**Cheshire West and Chester Council's response to the
to the Applicant's comments to Cheshire West and Chester's Written Representation submitted at Deadline 1 (17 April 2023) [REP1-061]**

Submitted at Deadline 3 – Tuesday 23 May 2023

This document represents a table of responses to the Liverpool Bay CCS Limited (“the Applicant’s”) response to the Cheshire West and Chester Council’s (“the Council”) Written Representation submitted at Deadline 1 (17 April 2023), in respect of the Applicant’s application for development consent for the Hynet Carbon Dioxide Pipeline DCO (“the Project”).

Figure 6.1 – Extract of the Ince Park Plastics Masterplan - Drawing Number: 20039-FRA-XX-00-DR-A-90-0005 P2 approved under application no. 21/04076/FUL and works no.3, EN070007-D.2.4-WP-Sheet 1 [AS-012].

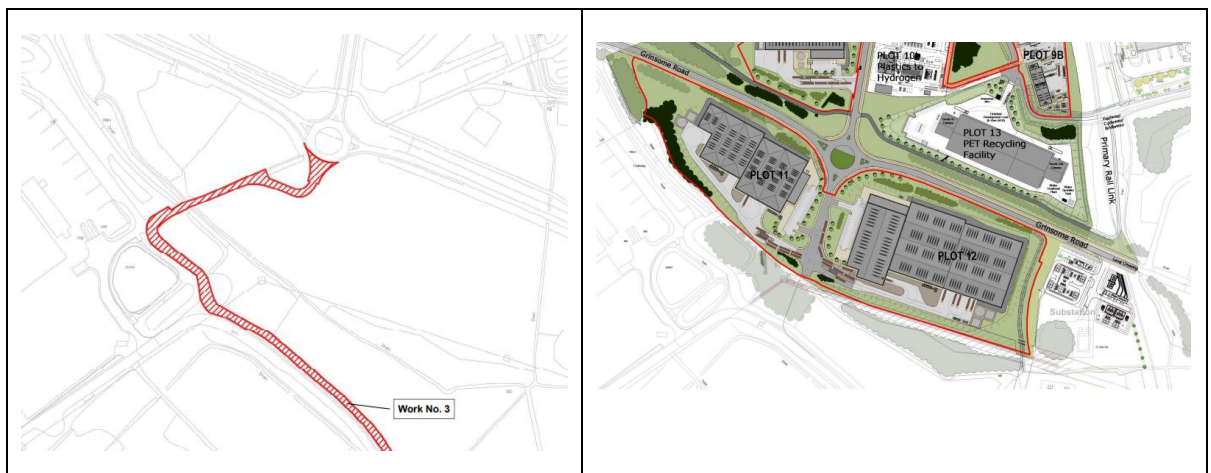
2.2.2	2.2	<p>The Council recognises the Project’s wider potential economic benefits in the region however there are some concerns raised in regard to the localised impacts. The Project has the potential for direct and indirect impacts upon existing local businesses including the delivery of safeguarded sites in the Local Development Plan (LDP). an approved plot and building of the Protos Plastics Park approved under planning permission 21/04076/FUL. This site is safeguarded through the Local Development Plan for employment uses and the DCO would sterilise part of the site</p>	<p>The Applicant notes this response from CWCC. In respect to the Protos Plastics Park, the Applicant refers to the responses given to [REP1-075] (document reference: D.7.16) and [REP1-074] (document reference: D.7.19) submitted at Deadline 2, regarding the site based impacts to the Protos Plastics Park and to the Peel SoCG [REP1-027] to be reissued at Deadline 2, in which these their concerns (including site access and potential sterilisation) are being addressed with that particular IP through frequent commercial discussions</p> <p>The Applicant notes the infrastructure delivered by the DCO proposal will be critical for the future development of businesses in Cheshire (as well as Flintshire). A number of the land-owning businesses impacted directly or indirectly are to some extent reliant on the development for their future plans. In the Ince-Stanlow area companies such as Peel NRE, Essar Oil UK, and Encirc, are land owners directly impacted but either require the CO₂ pipeline to be constructed for it to be used to transport CO₂ from their / their tenants’ production facilities or plan to use Low Carbon Hydrogen (from the Stanlow Manufacturing Complex), which requires 97% of CO₂ to be captured and transported using the CO₂ pipeline.</p> <p>Looking further into the future, the CO₂ Transport Pipeline will be an asset for local industry and land owners and (as part of future developments and conditional on future consents being given) is likely to attract businesses to develop and/or expand their operations in the region, including the Protos Plastics Park.</p> <p>In general response to Economic Impact, the Applicant would like to draw the ExA’s and CWCC’s attention to the Applicant’s Response to the ExA’s ExQ1 at</p>	<p>This matter is detailed in Part 6 of the Council’s Local Impact Report [REP1A-002].</p> <p>Whilst the Council is aware of the ongoing negotiations with landowners, it is noted that the Applicant has not addressed the issue of the direct impact from the potential loss / sterilisation of part of a strategic site, and with no alternatives or suggestions put forward to resolve this matter the Council would maintain its concerns on this matter.</p> <p>In addition to the access issue raised regarding the Protos Plastics Park, as outlined in paragraph 6.8 of LIR [REP1A-002] the Council also note that the Project’s permanent access at Ince, Work No. 03 of the Works plans within Part1 of Schedule 1 of the dDCO [REP1-004], could also potentially impact upon a proposed significant expansion of the adjacent Encirc glass manufacturing facility which is on a site safeguarded under the LDP for employment use (EP2 and EP2A). Full permission is sought, and currently being determined by the Council with a decision likely within the next couple of months, under application no. 22/03693/FUL, for the erection of an automated warehouse (Use Class B2/B8), ancillary office space, an automated link between the automated warehouse and existing facility, a driver welfare building, HGV marshalling yard, security building and other associated works.</p> <p>As shown below, the permanent access under dDCO Work No. 3 would cut through the proposed HGV parking area and would potentially affect the proposed access layout.</p>
